Approval of details reserved by condition imposed under ref A/44/18/PL relating to Condition No 3 site set up and No 6 detailed remediation scheme.

The Vinery Arundel Road Poling BN18 9PY

This condition is discharged in so far as submission of details relates and refers to the submitted Site Management Plan drawing 17029-A-PL24 Rev A.

drawing No: **17029-A-PL24** revision: **A**

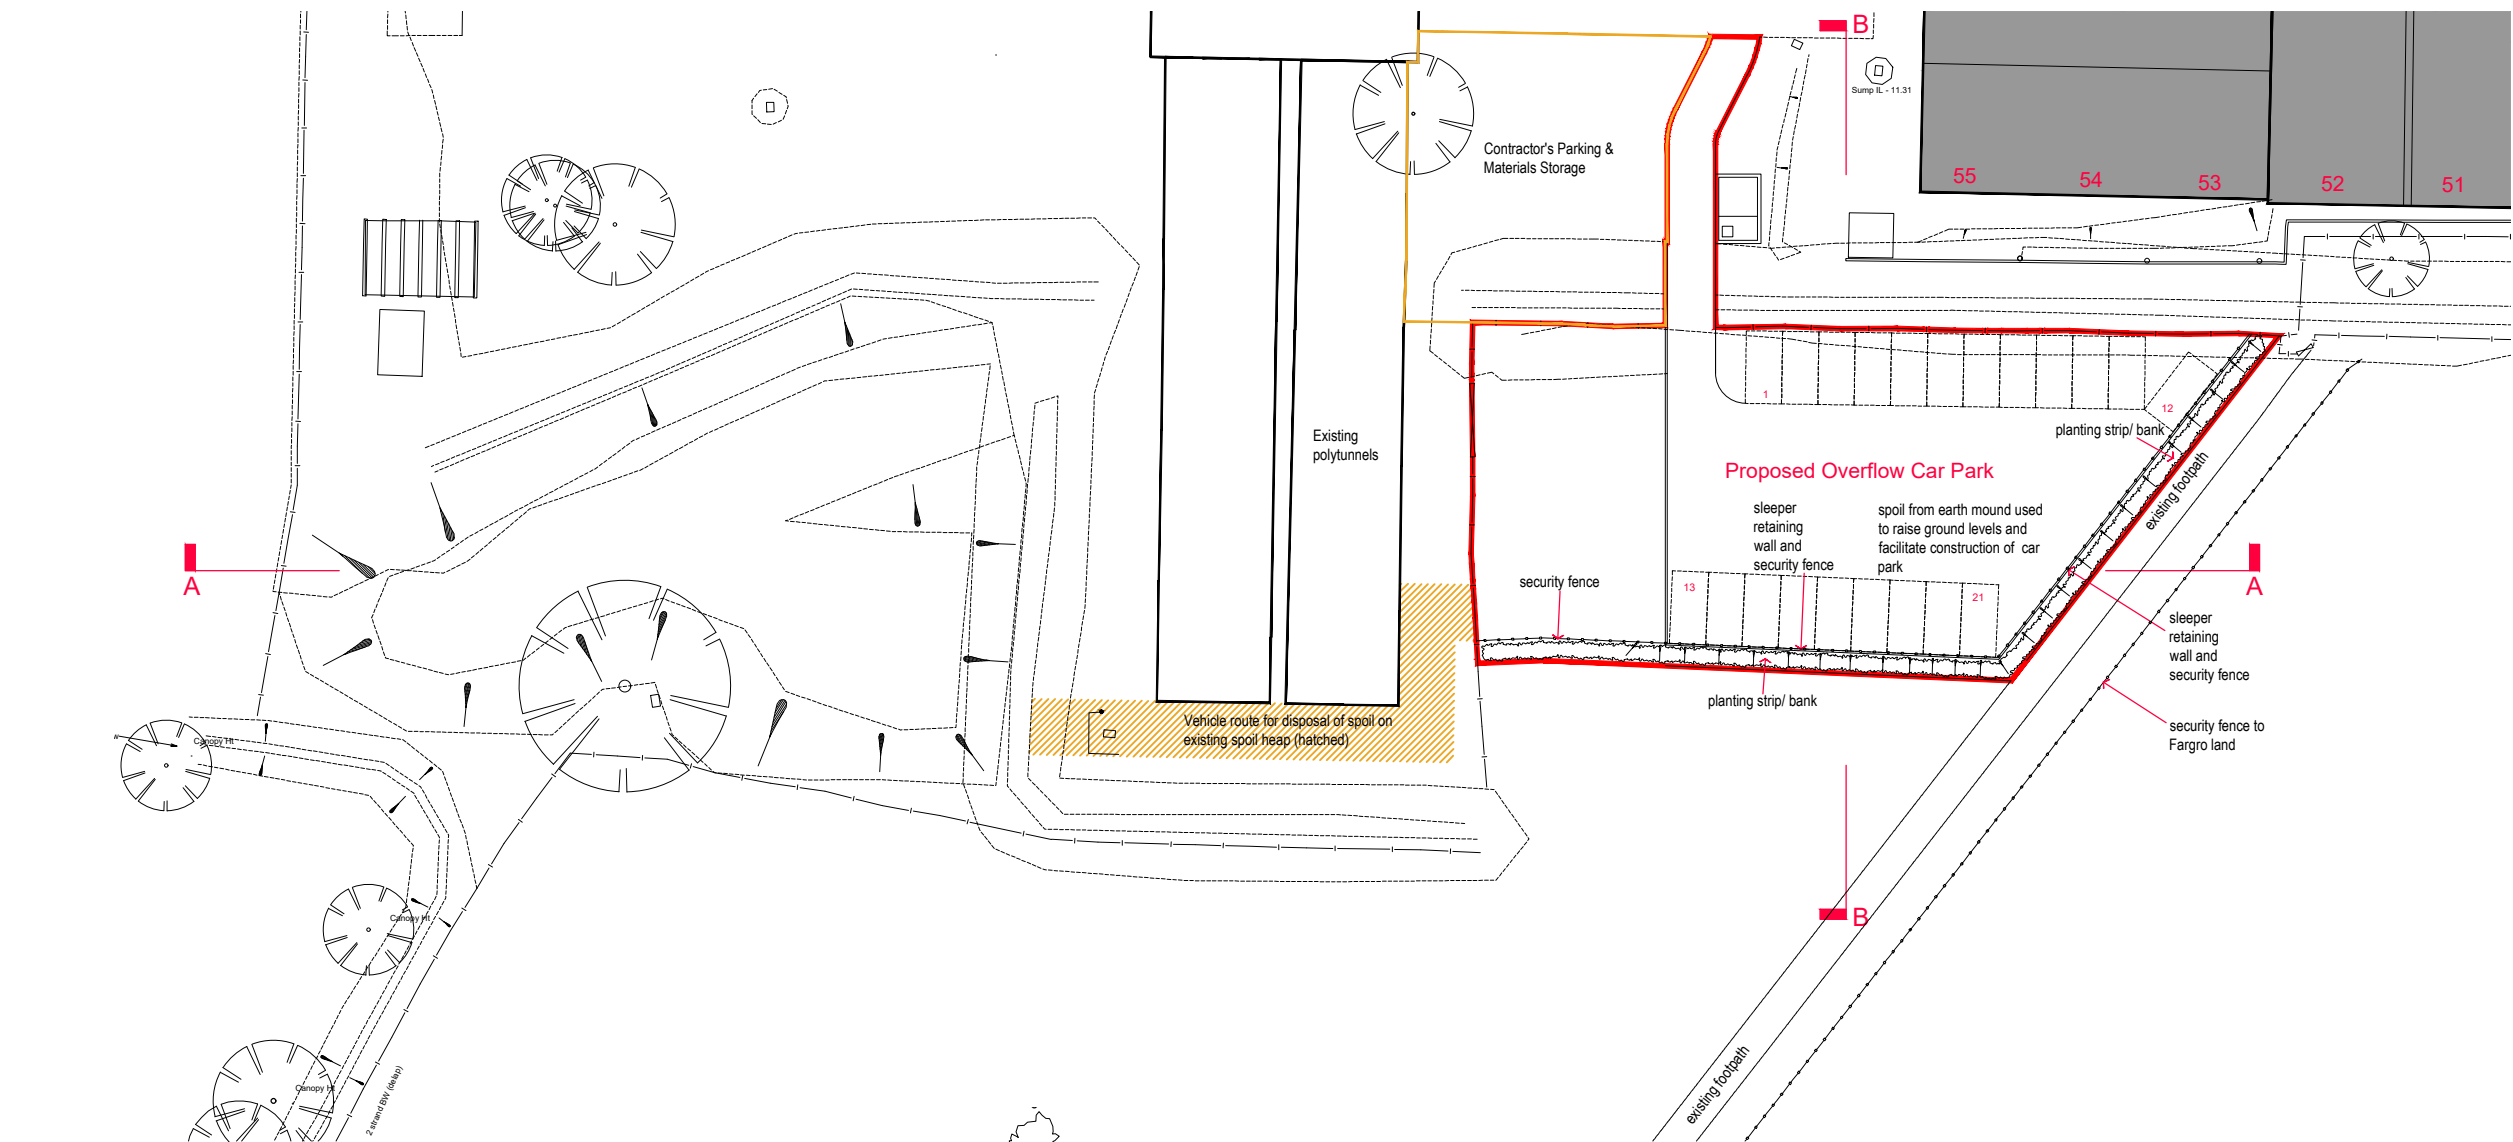
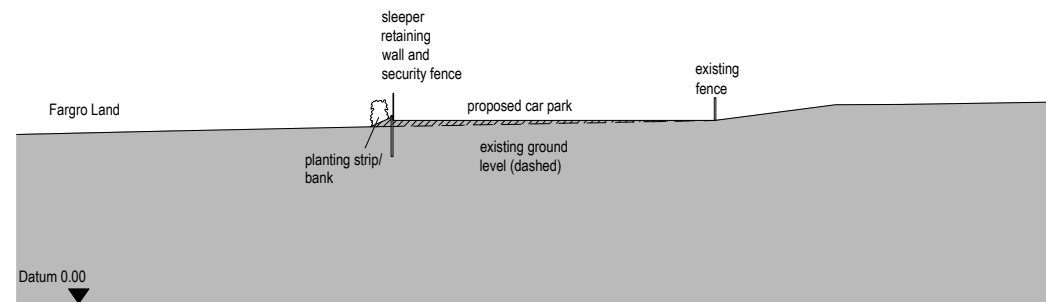
The Footpath (ANG/2200/2) runs adjacent to the works site - this path will need to be protected and open during the works. In addition, works should not impact on the integrity of the footpath. It is requested that the applicant contacts the PROW officer for their approval.
